**RE: NORTH WEST GROWTH CENTRE WATER-RELATED SERVICES
STAGE 1 PRECINCTS (APPLICATION: 07_0125)
ENVIRONMENTAL ASSESSMENT**

Environmental Assessment – North West Growth Centre water related services for first release precincts

Subject: Major Project – North West Growth Centre Water Related Services for First Release Precincts

Figure 2: Pipeline and Plant Locations

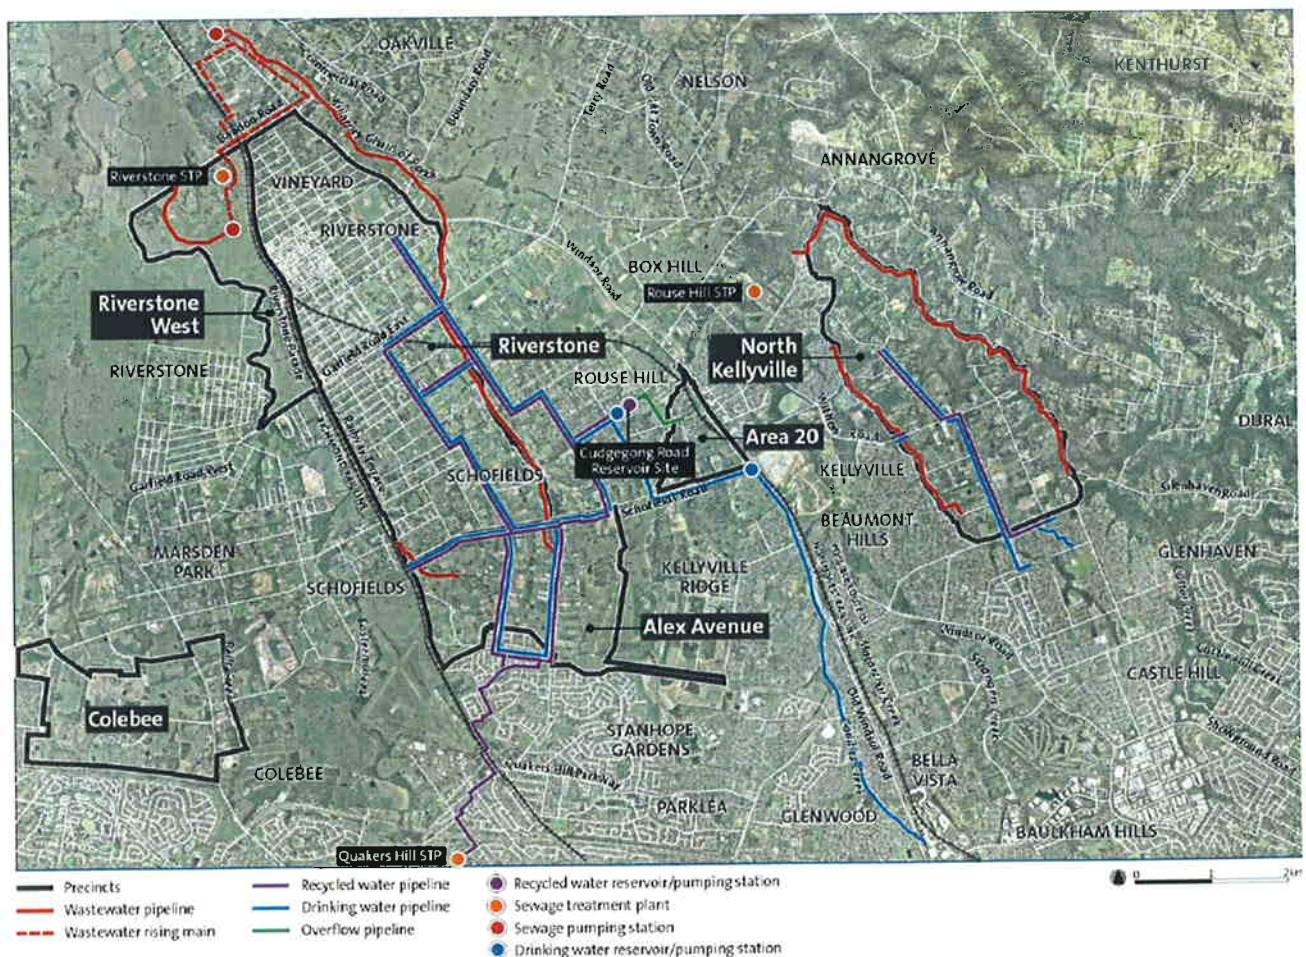
- There is no mention of the Alex Ave or Burdekin Road 250 mm water mains in the staging table, although these are included in the scope of works in Table 3.2 on page 3.7 of the EA and shown on Figure 3.1. Clarification of the timing of these would assist in understanding the overall servicing program.
